Our ref: DOC19/1027445

Senders ref: SSI-9737

**Subject: EES comments on Environmental Impact Statement for Sydney Gateway Project – SSI-9737 – St Peters interchange to Sydney Airport**

The Environment, Energy and Science Group (EES) has reviewed the EIS and relevant technical working papers and provides its recommendations and comments at Attachment A.

Figure 7.3 Project layout - map 1

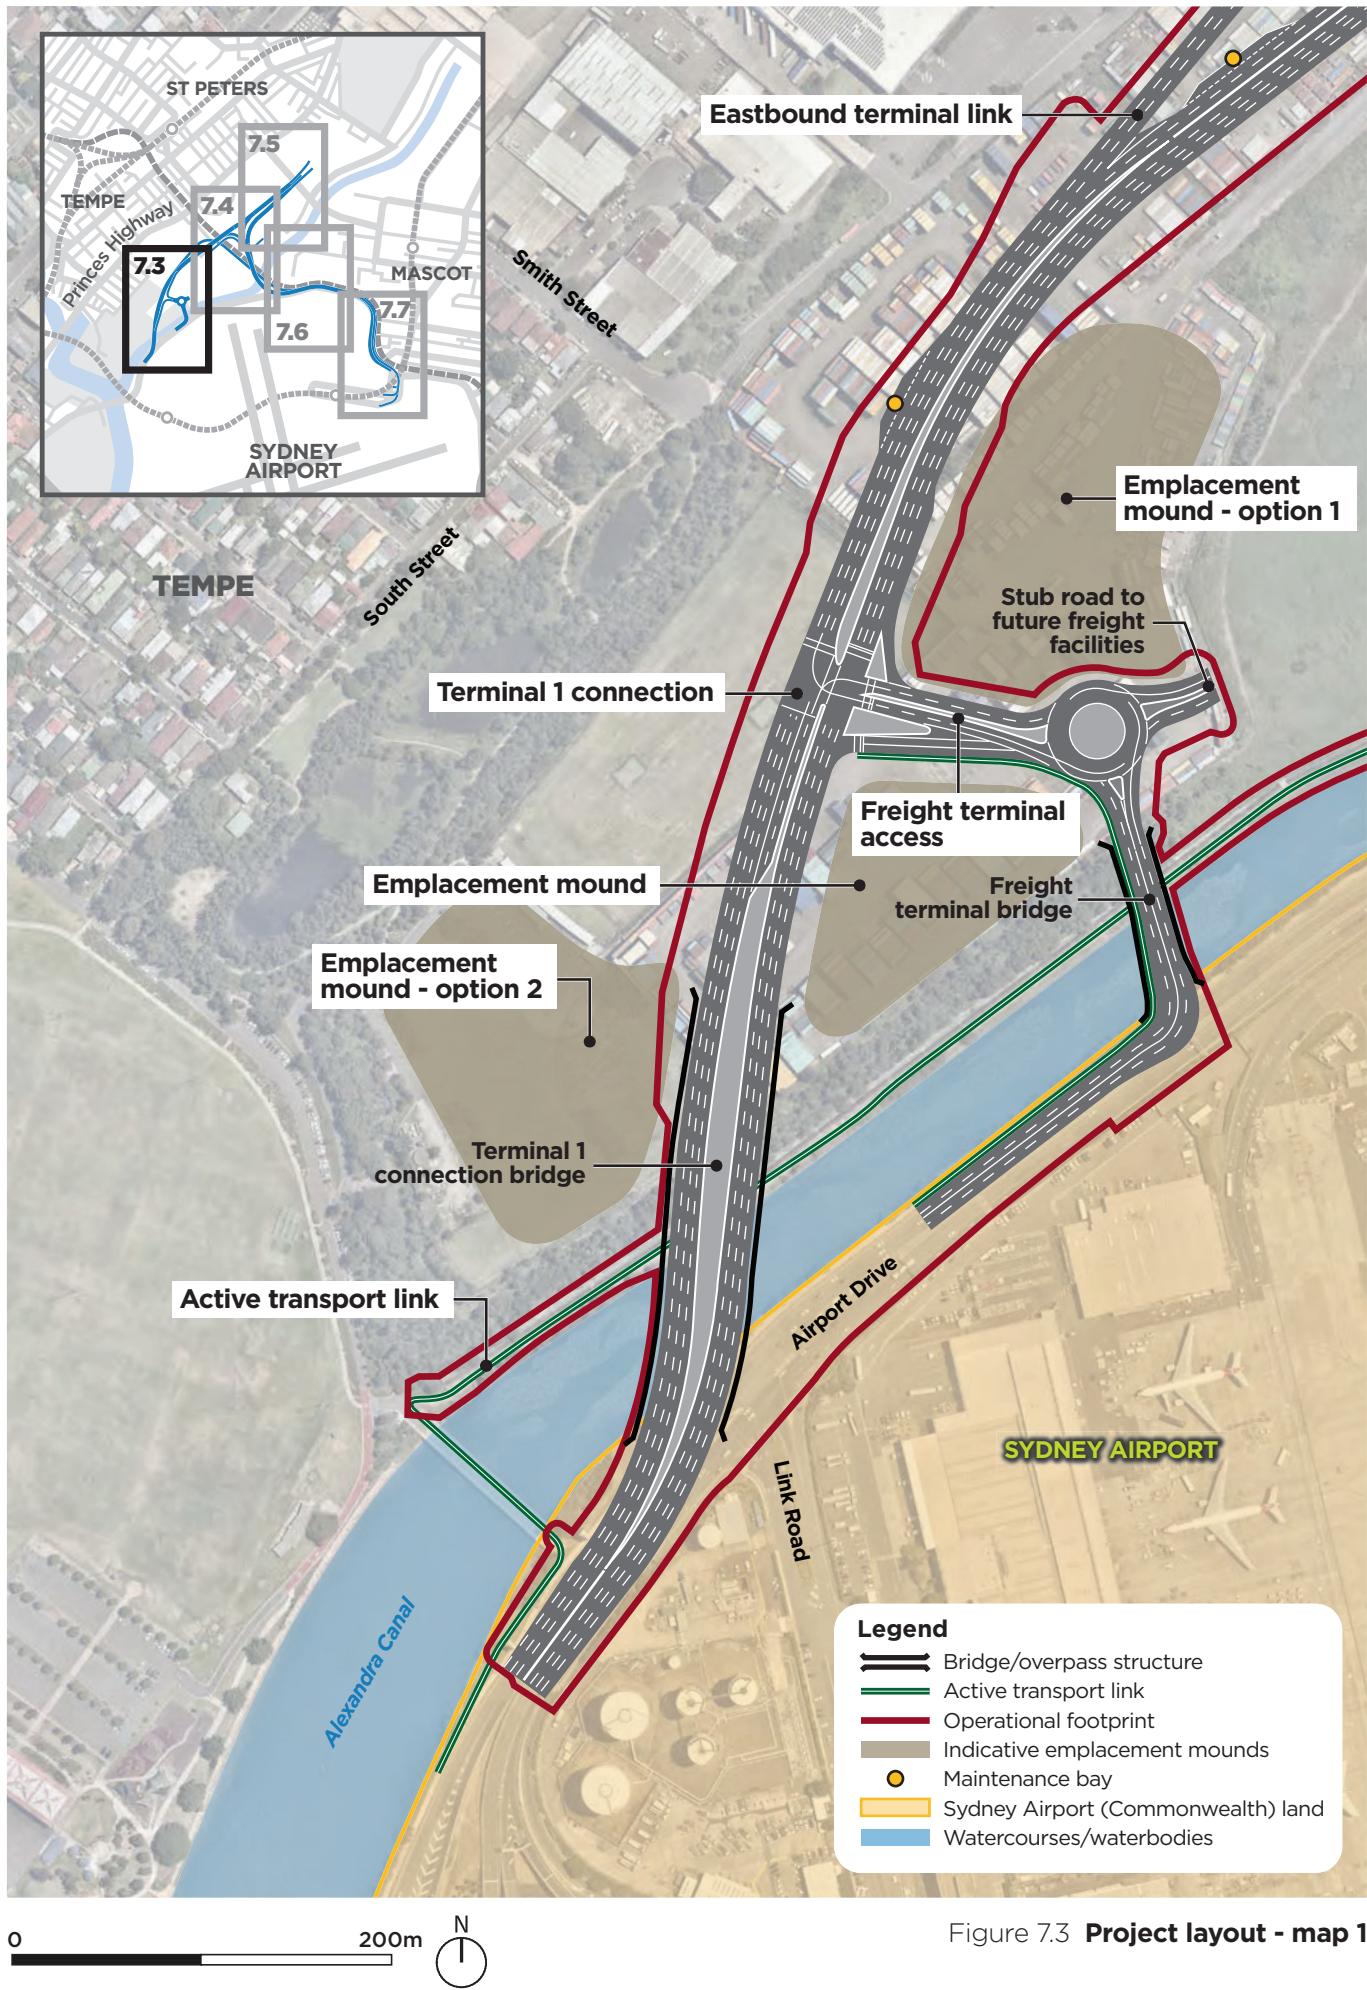
- Terminal 1 Connection bridge (page 7.14, Figure 7.3)
- Qantas Drive bridge (pages 7.19-7.20, Figure 7.4)
- Terminal link bridge (page 7.23, Figure 7.4)
- Freight Terminal bridge (page 7.28, Figure 7.3).

Comparing Figures 7.3 and 7.4 with Figure 22.2 indicates that the footprint of the Terminal 1 Connection bridge, the Freight Terminal bridge and Qantas Drive bridge would result in the clearing of Swamp Oak Floodplain forest. The RTS needs to clarify why it is not possible to move and/or design these bridges to avoid clearing the Swamp Oak Floodplain forest.

EES recommends the bridge design maintains and improves riparian/terrestrial connectivity along Alexandra Canal and includes the following:

- bridges are elevated and span the full width of the riparian land to avoid or reduce the need to clear and/or disturb native vegetation
- the design maximises light and moisture penetration under the structure to encourage native plant growth.
